South West Forest Services

Application by Highways England (the Applicant) for an Order granting Development Consent for the A417 Missing Link (the Proposed Development)

Scoping consultation and notification of the Applicant's contact details and duty to make available information to the Applicant if requested

Location: A417 Gloucestershire

**2.13 Trees and Hedgerows to be Removed or Managed Plans - Part 2 of 2**

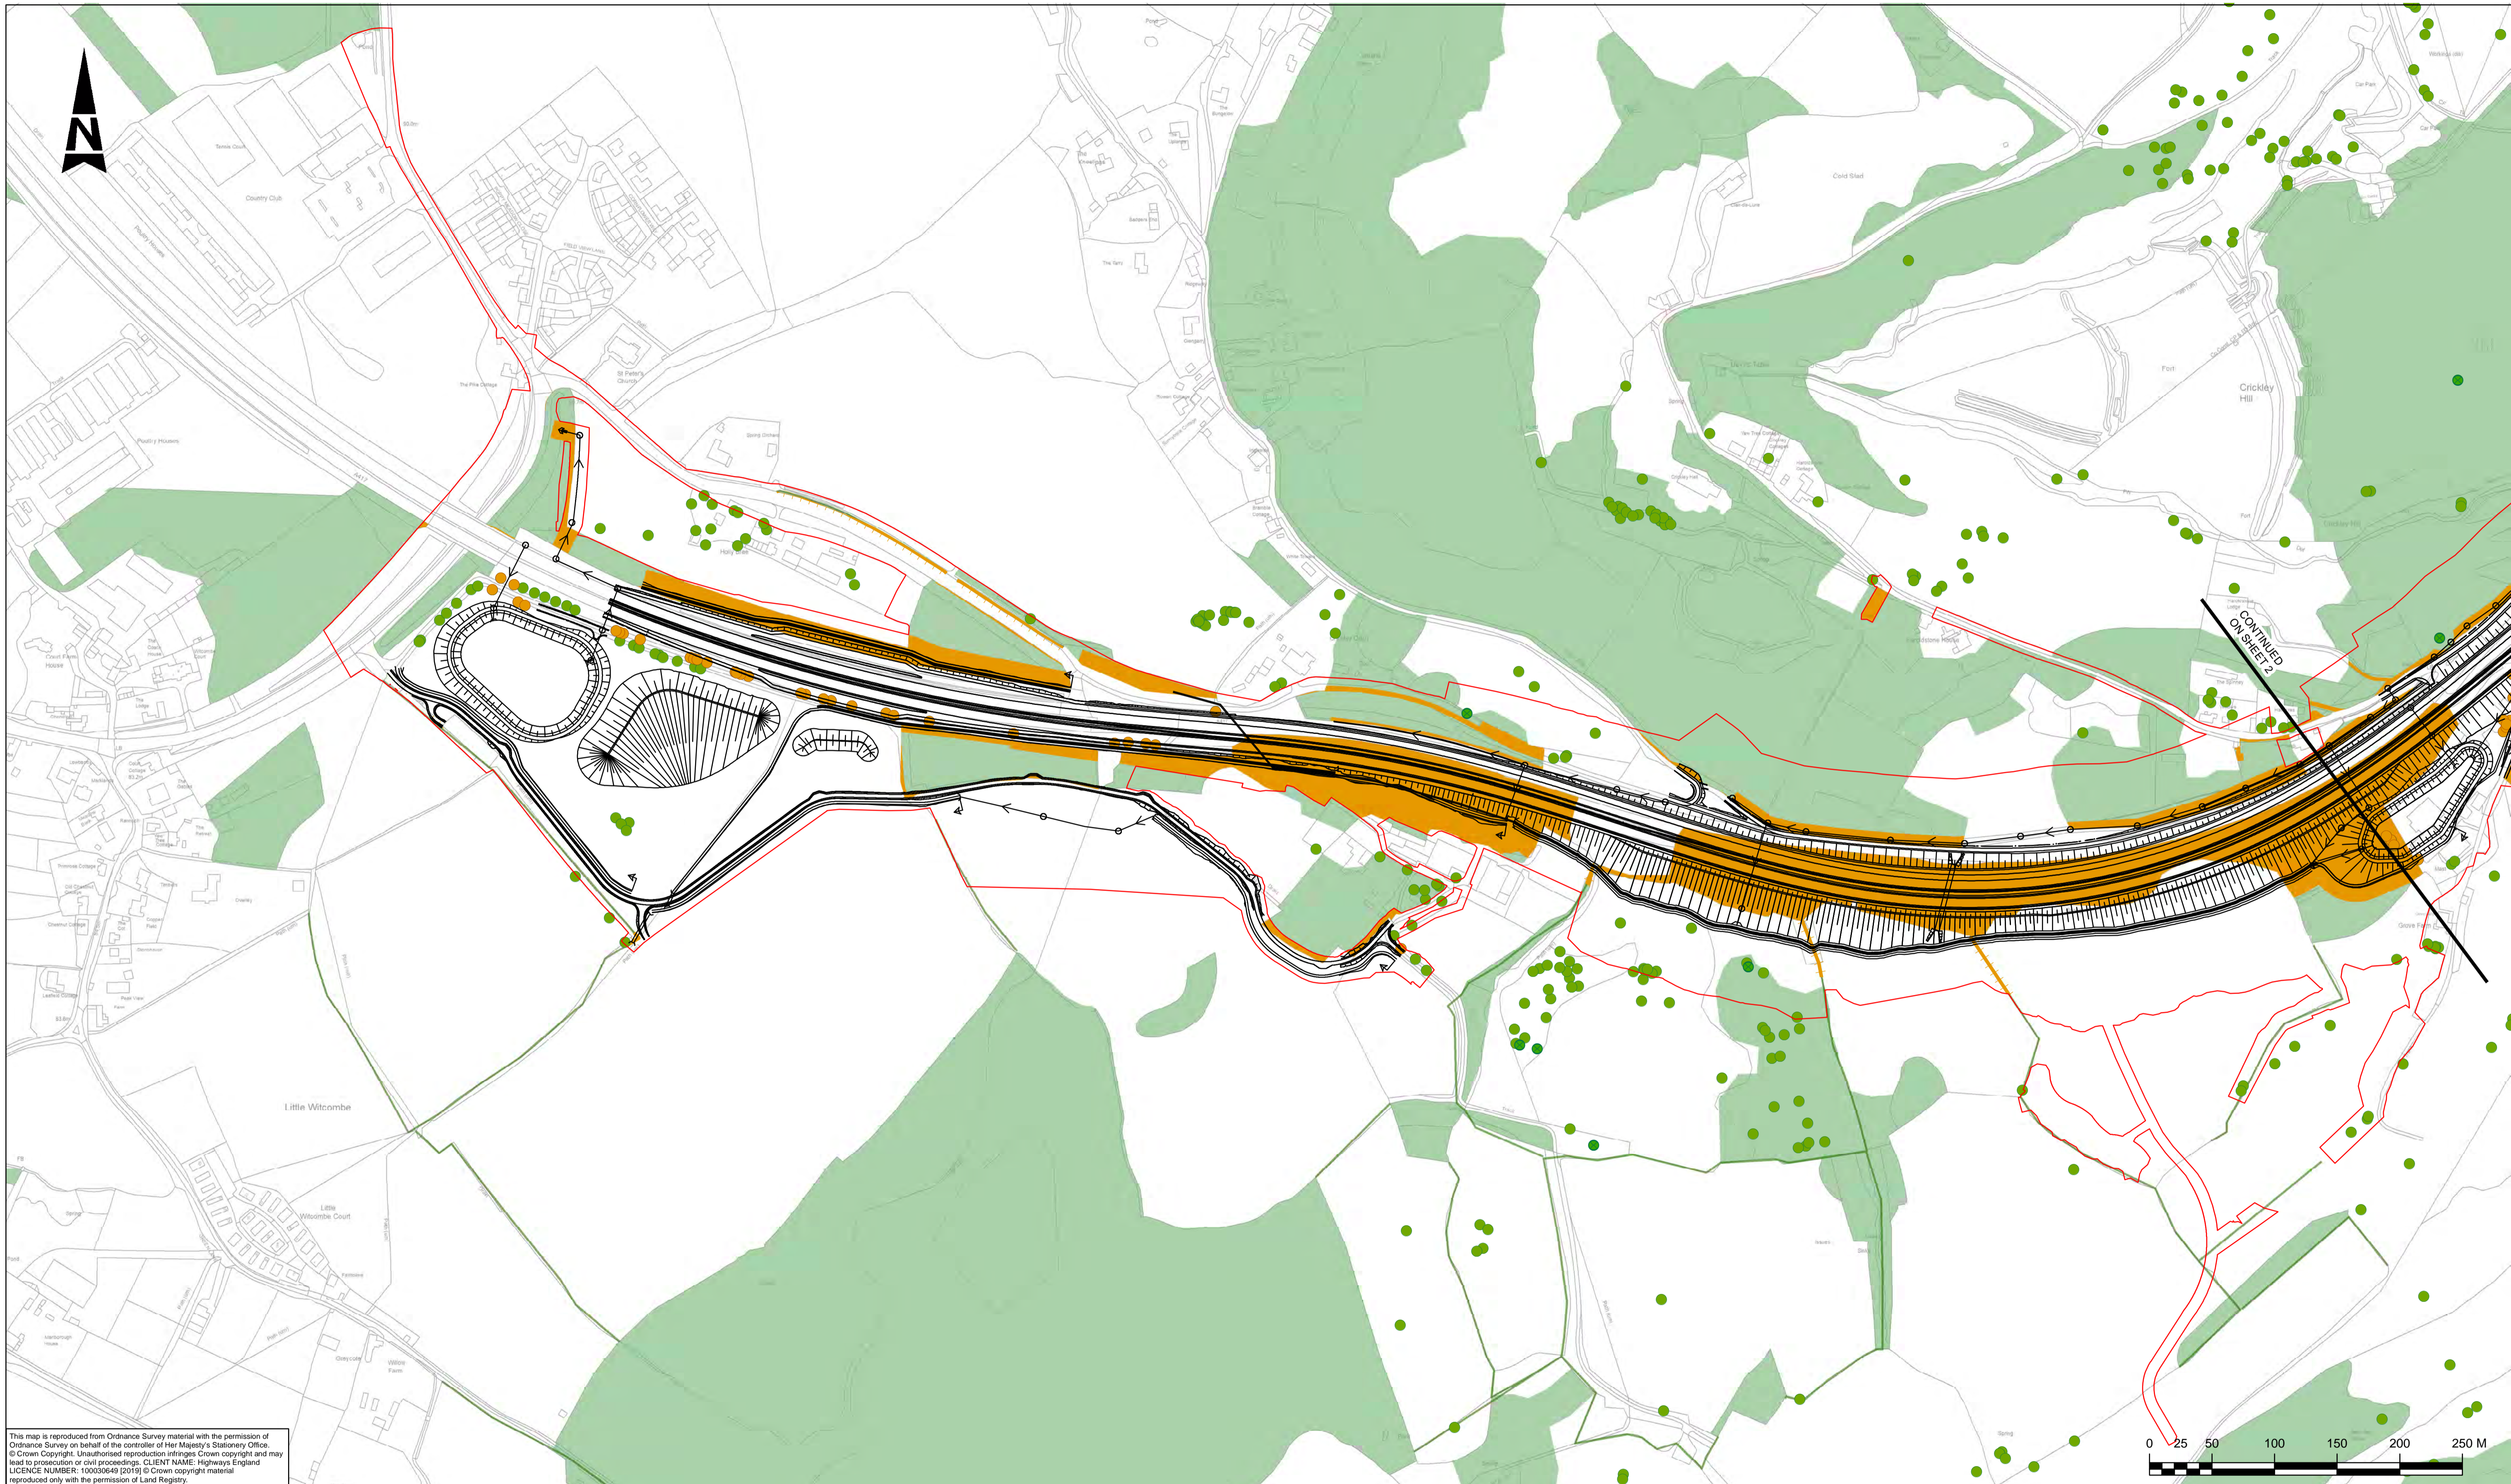
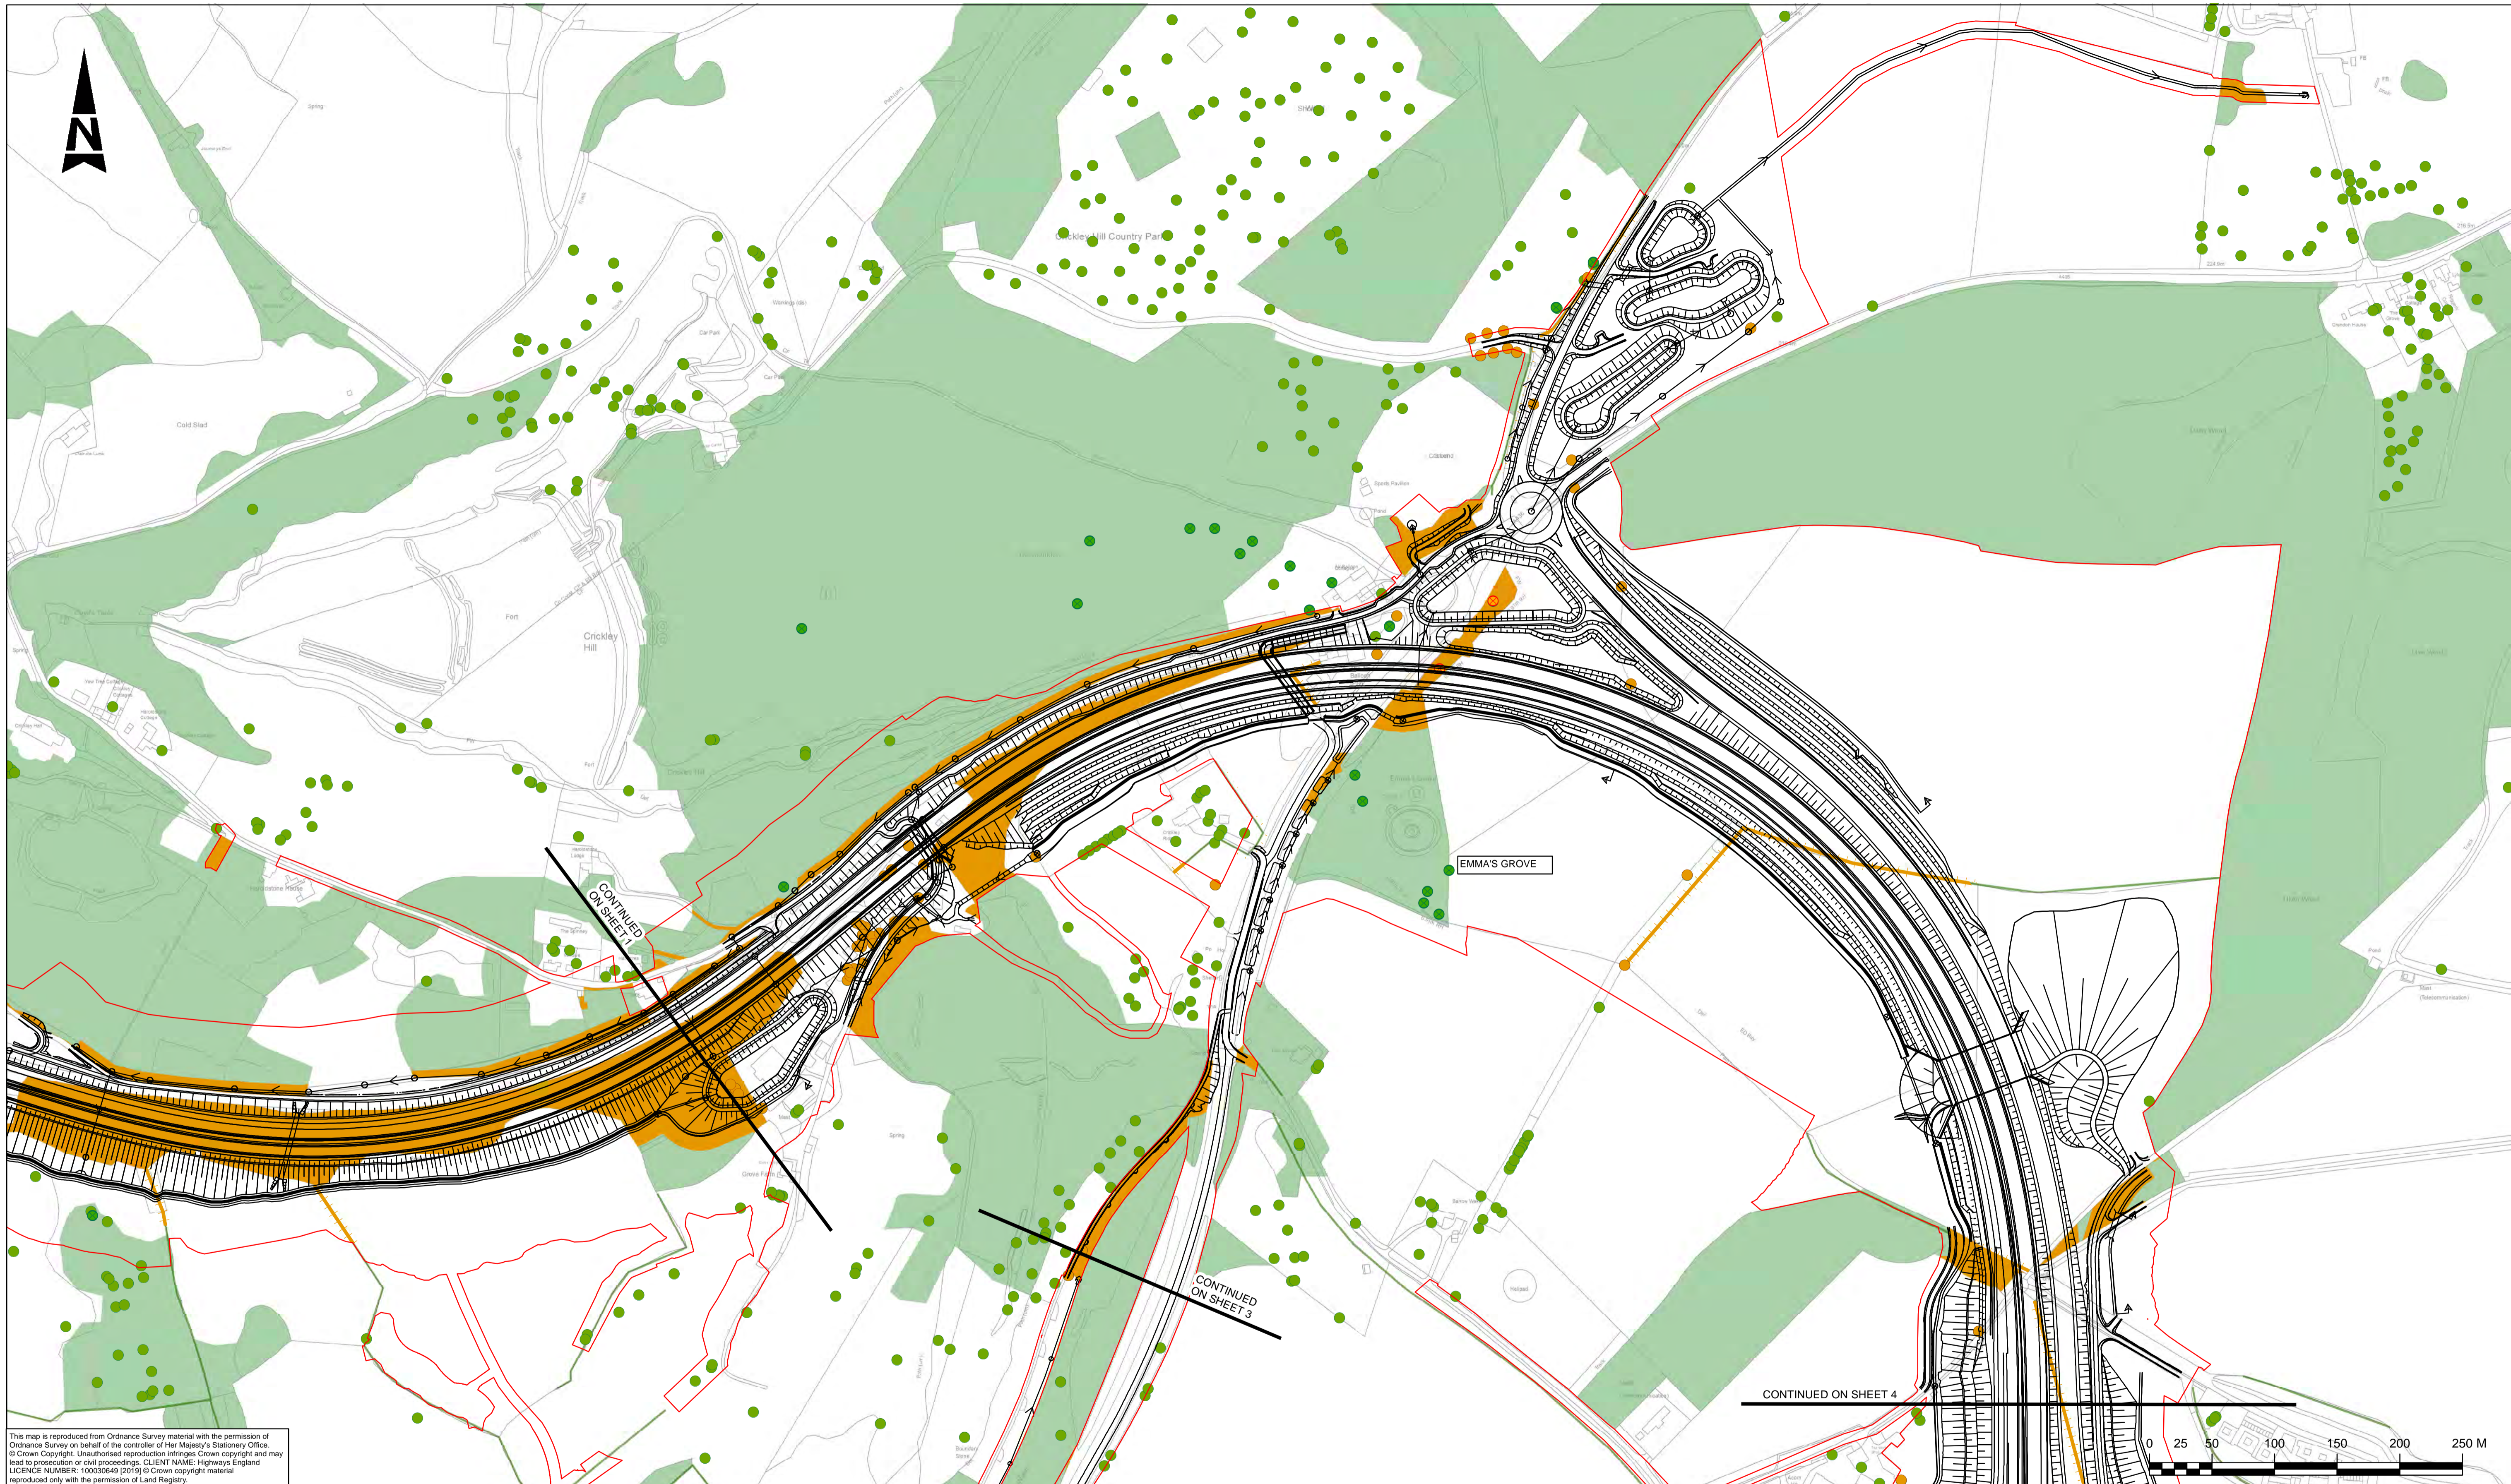
I note that there is a proposal to remove an area of presumed ancient semi-natural woodland which is too small to be on the register but which will be treated as ancient woodland. Our advice would be that no presumed ancient woodland should be removed. It is important that there is no net deforestation so any loss of woodland should be compensated for. Ideally schemes will lead to an increase in woodland cover.

Although there are no large woodlands on the proposed route, there are several existing felling licences and woodland grant agreements in the vicinity of the proposed scheme. It will be important to ensure that the new scheme design does not make it difficult to access and manage any existing woodlands, or to make the recreational use of woodland less enjoyable. Ideally it will enhance opportunities to access, carry out work and extract timber from sustainably managed woodlands.
